**OXFORDSHIRE COUNTY COUNCIL'S RESPONSE TO CONSULTATION ON THE
FOLLOWING DEVELOPMENT PROPOSAL**

Application no: 14/01835/REM

Proposal: Reserved matters to 05/01337/OUT – details of the proposed village square including 44 public parking spaces and landscaping public open spaces

Location: Longford Park Phase 2, Longford Park Road, Bodicote

Title
**Planning Application 3:
 Village Square**

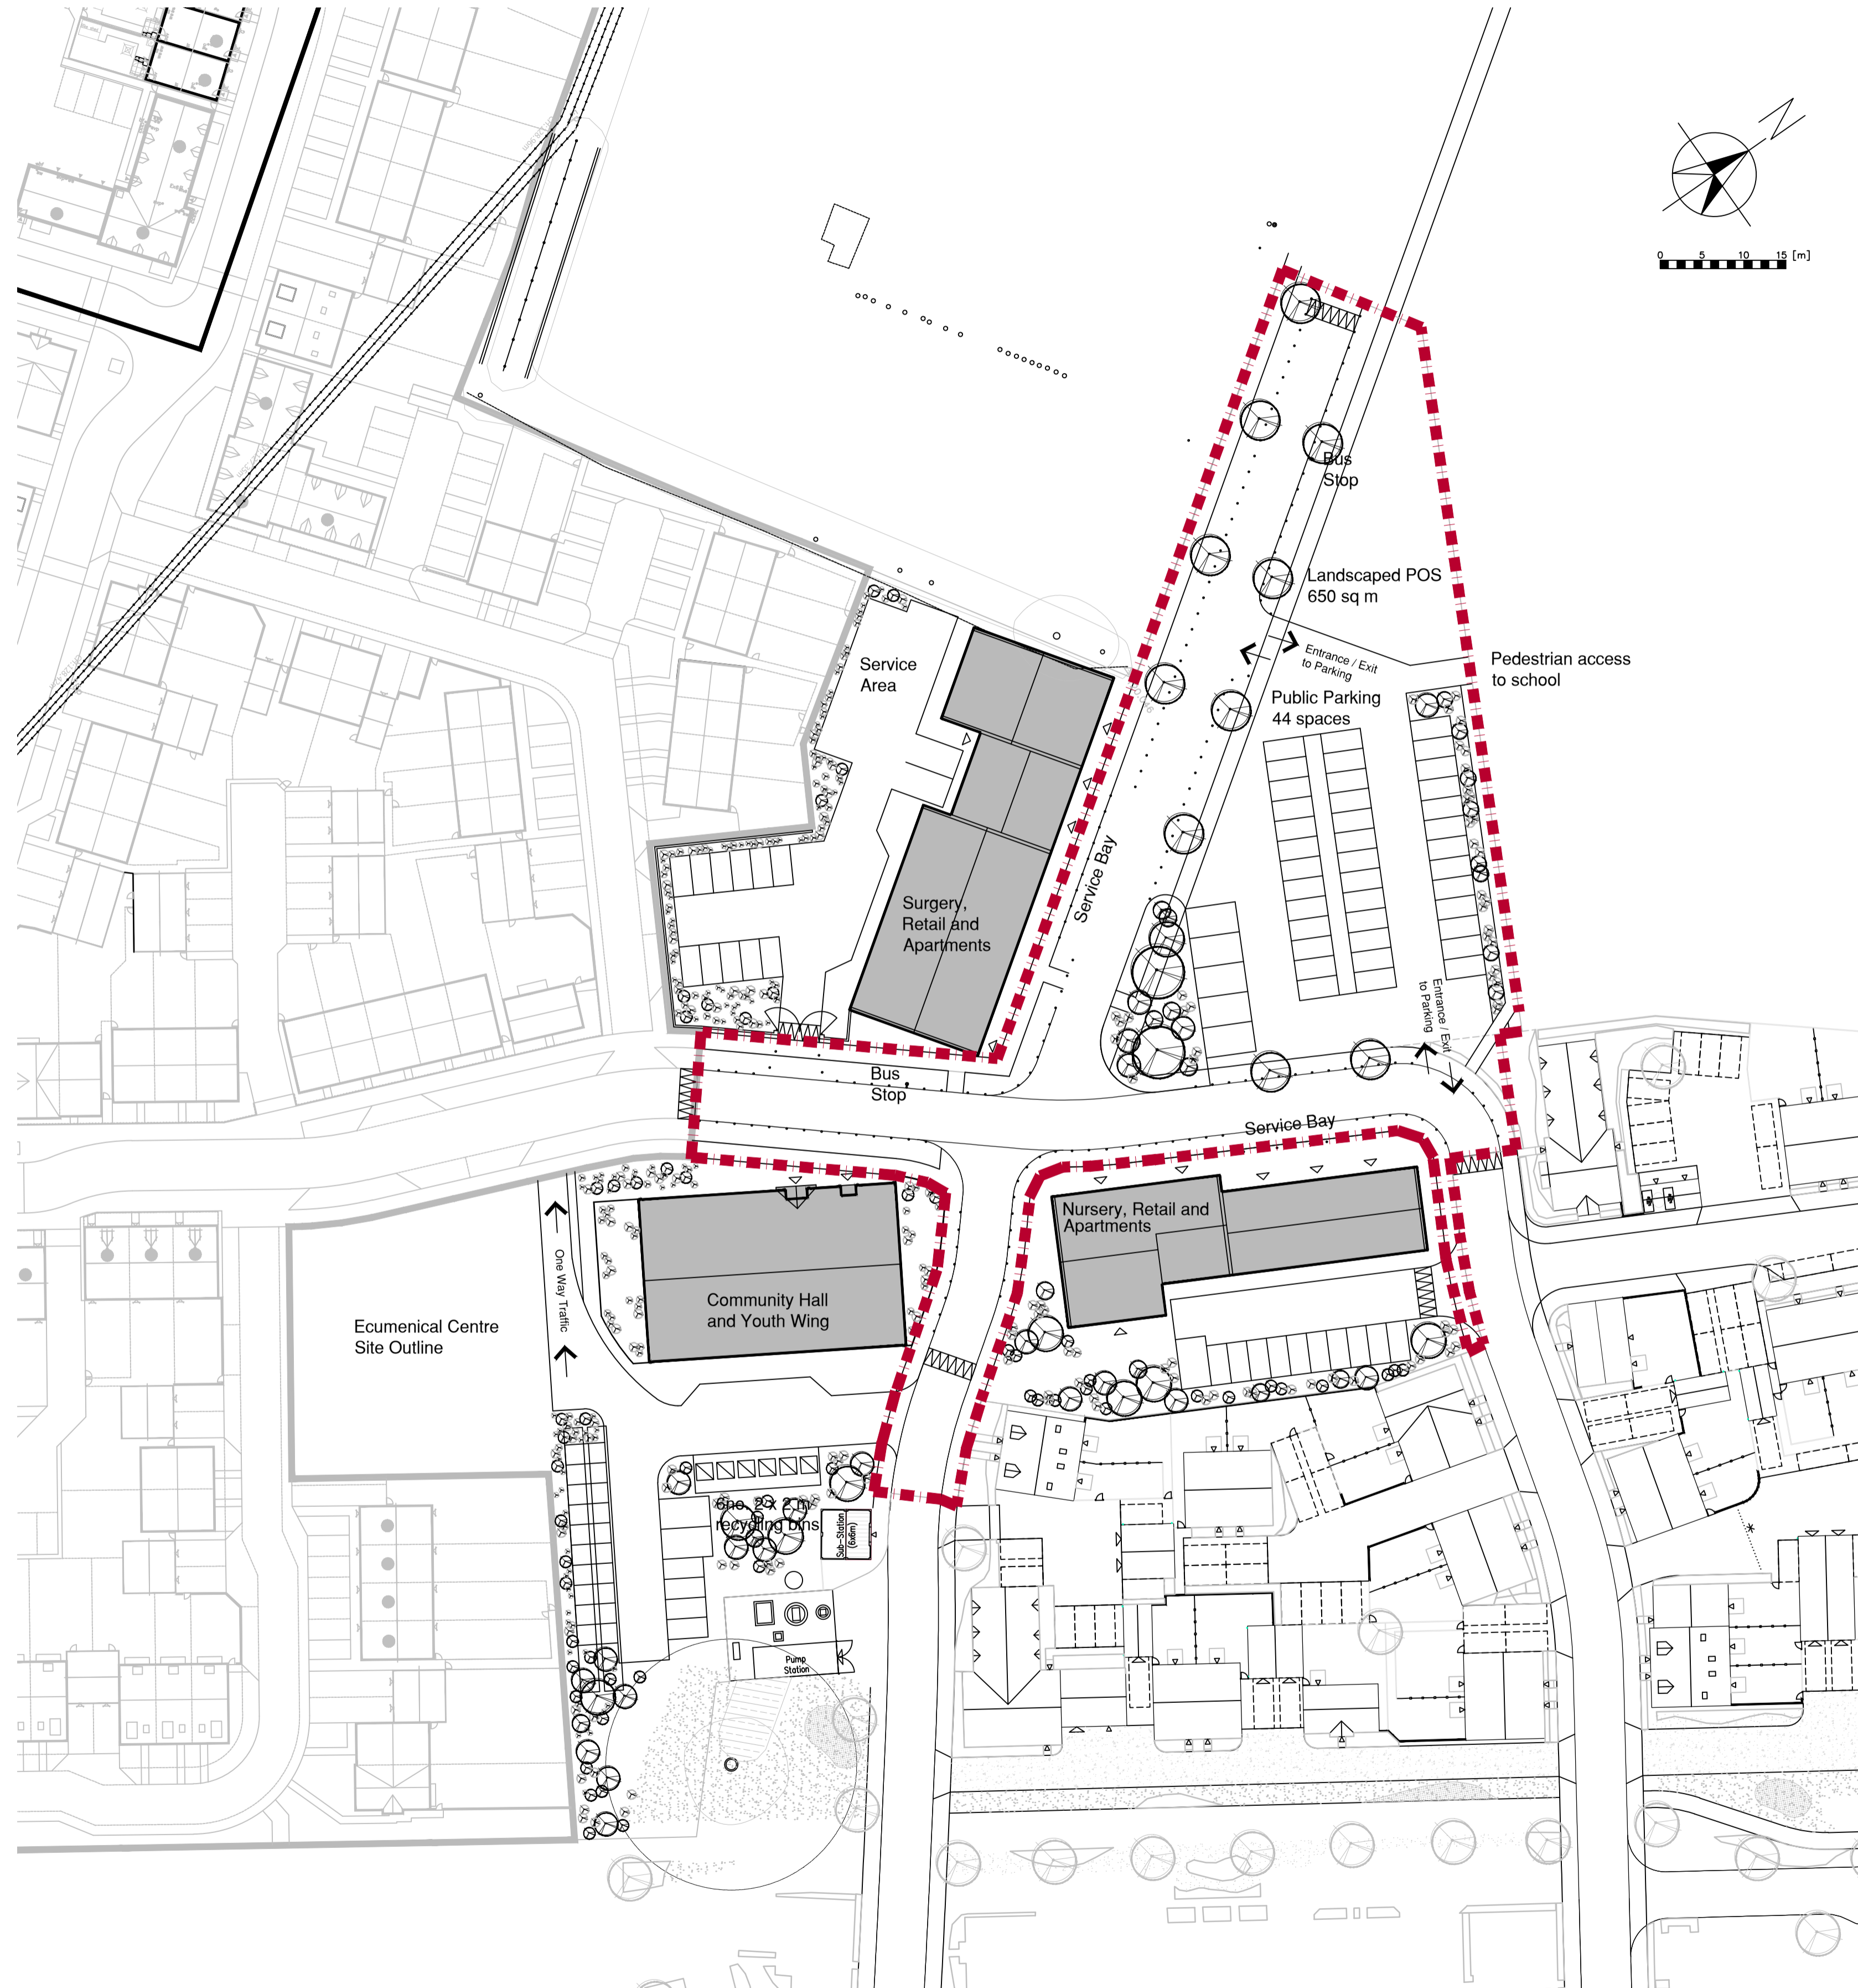
5. The surfacing to the parking area should be permeable paving and a condition should be applied to any permission to ensure that prior to occupation the parking area is constructed SUDS compliant.
Reason to accord with Sustainable Drainage Systems (SUDS)

- Carriageway Layout is different to that of the latest Longford Park Planning Layout drawing no.0476-102-12 Revision G
- The access points are located in the incorrect location as per the drawing no.0476-102-12 Revision G
